From: Amanda Scholes on behalf of Planning.Responses
Sent: 28 June 2019 09:36
To: Planning Scanning
Subject: FW: Planning Consultation on: F/9/19/PL

Comment from Greenspace

Site Address: Land Adjacent Station Cottages Ford Road Ford
BN18 0BH

Description of Works: Change the use of 1/2 the site area to a hard
standing storage area

Appendix B Topographic Map of the Site

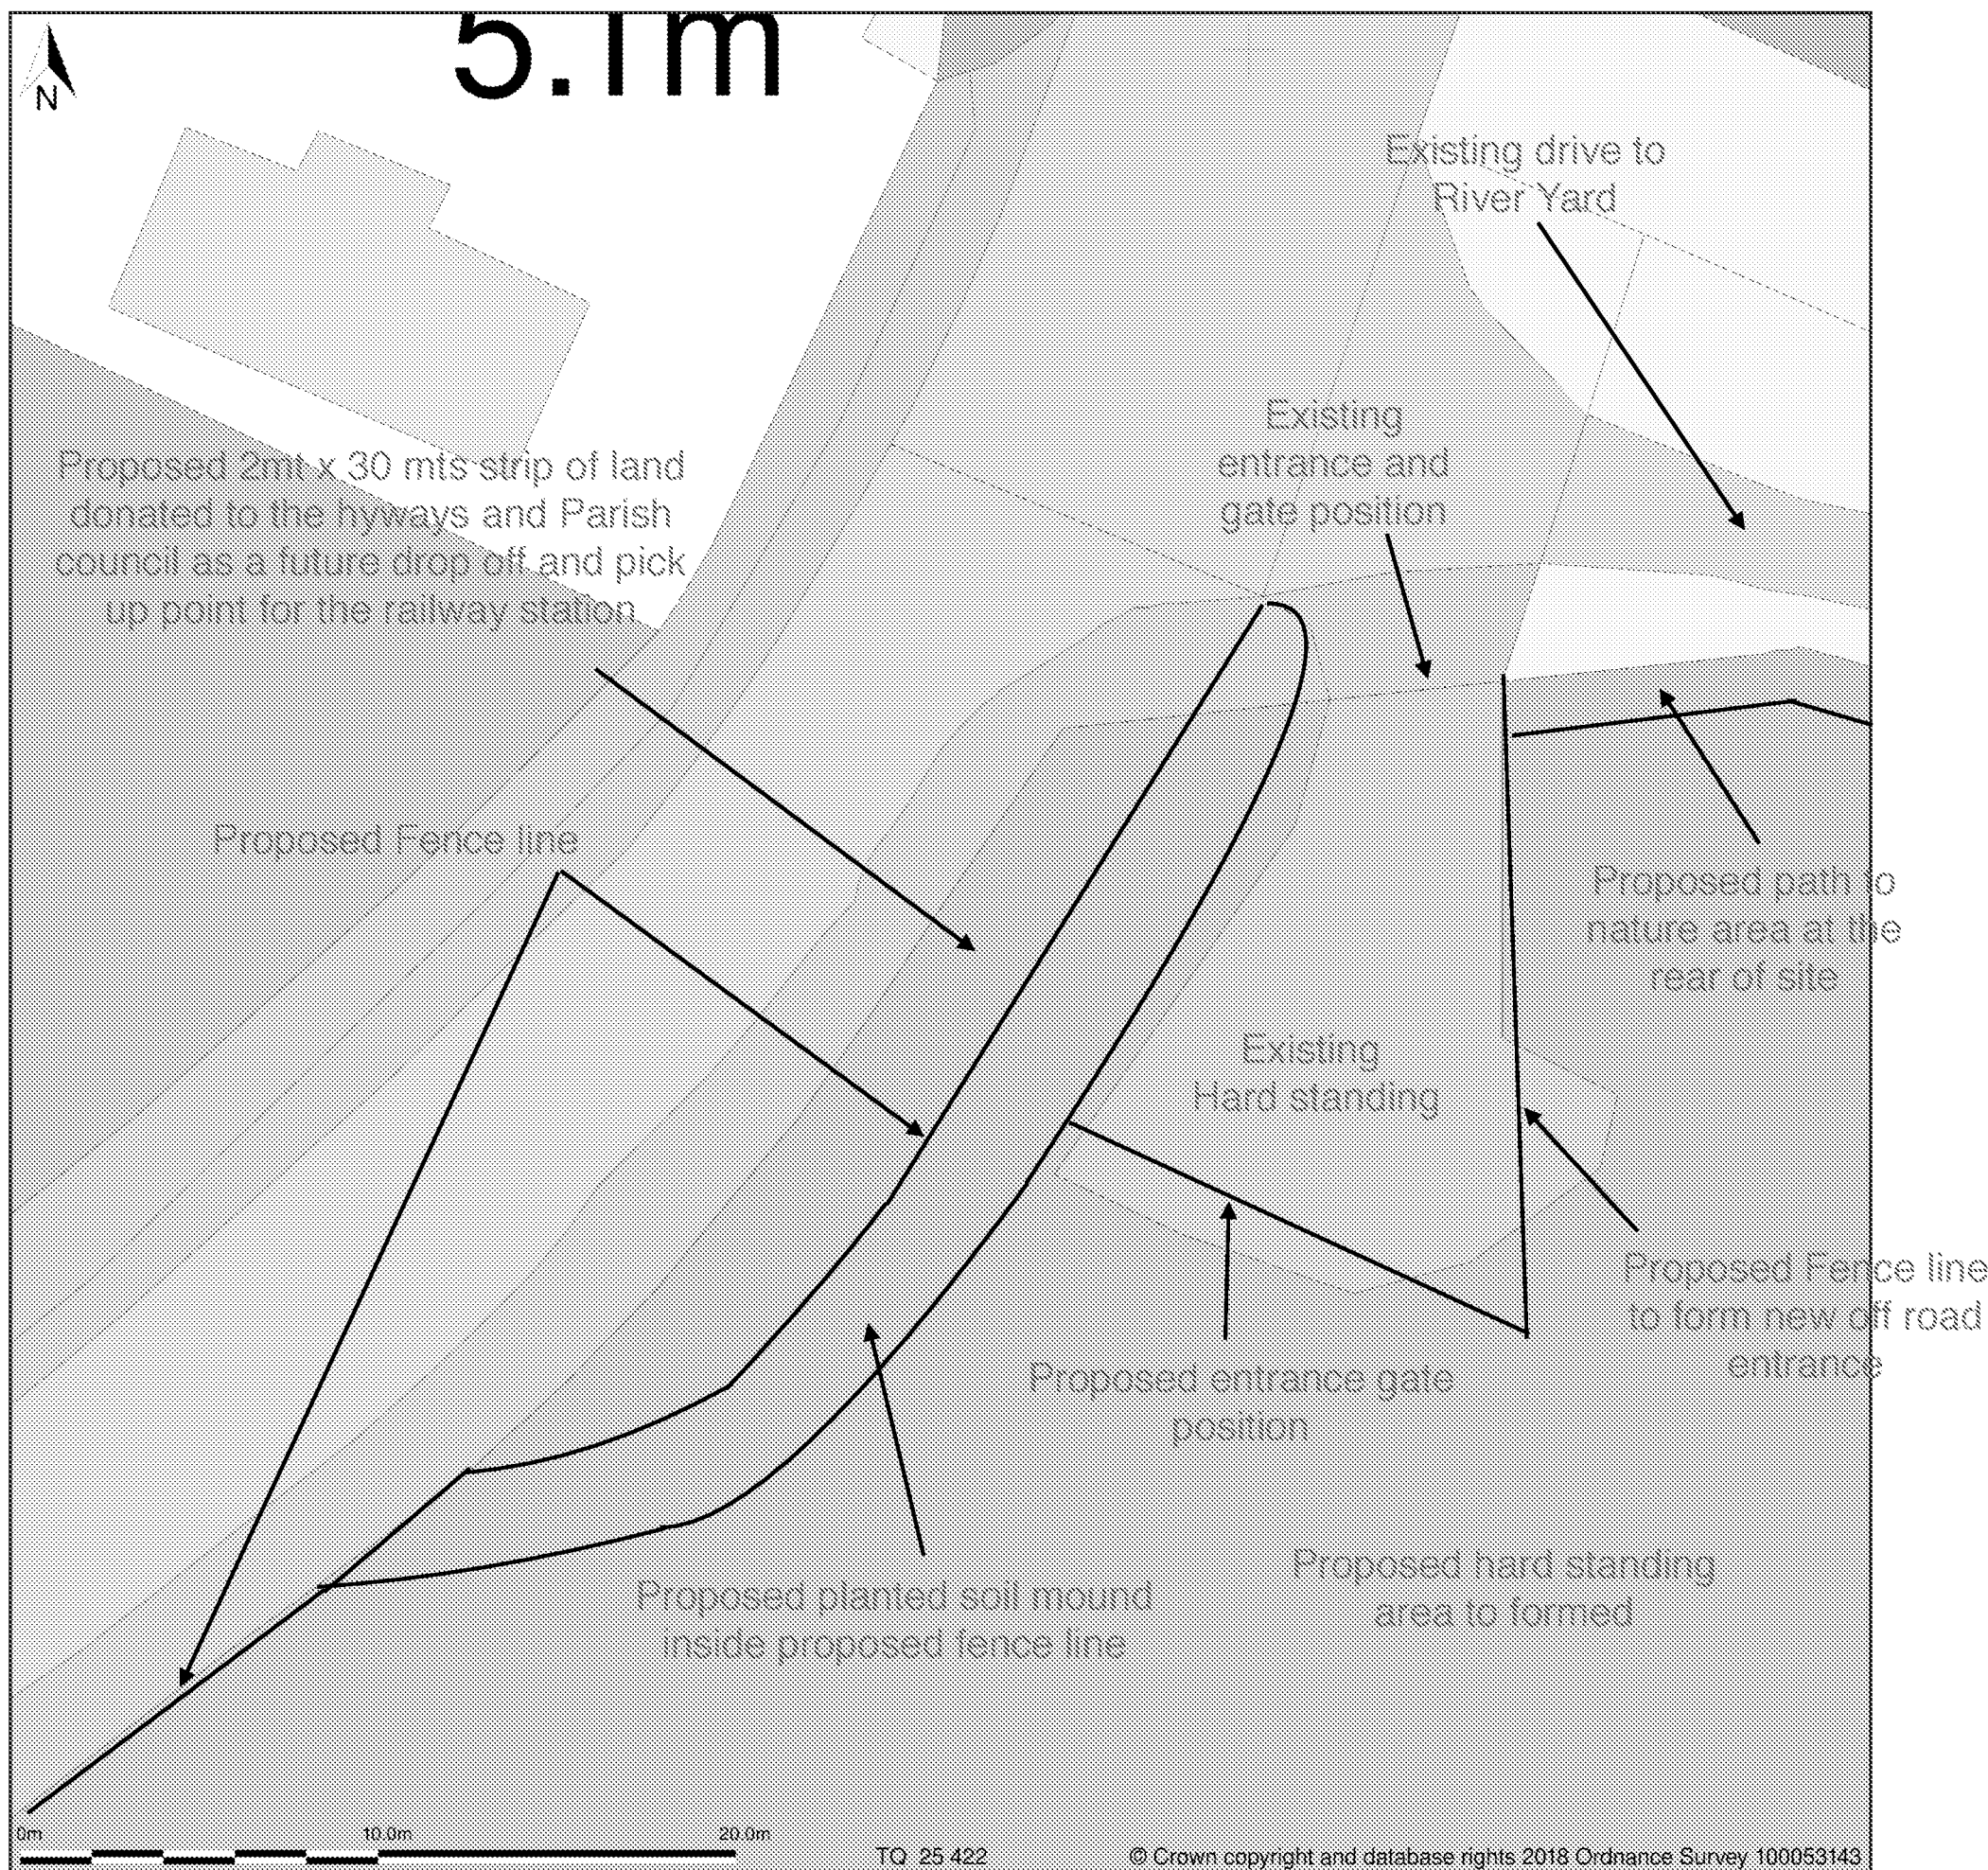
I would be concerned by the loss of trees/hedges and greening that this site presently presents and the relationship of 'proposed hardstanding' in relation to the proposed nature area and how these would work together.

Proposed Fence ans earth monud elevation

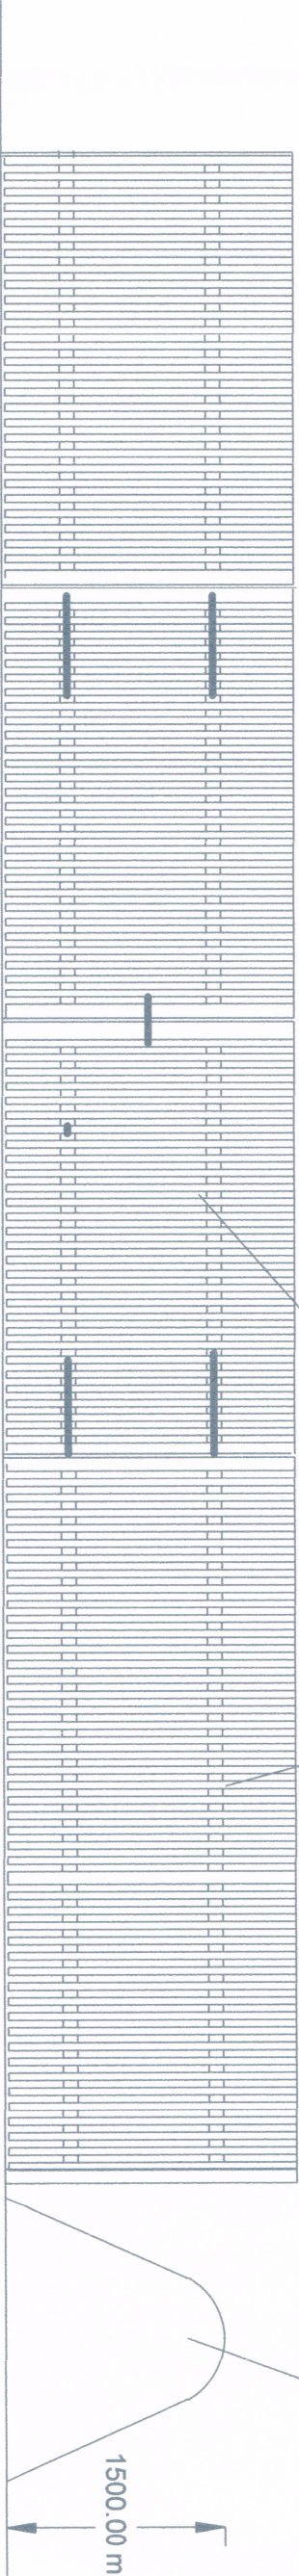
I would require at least to be conditioned with any decision, cross section of these two areas including the indicated 1.5m bund and the treatment/planting along with the proposals to hide the fence line.
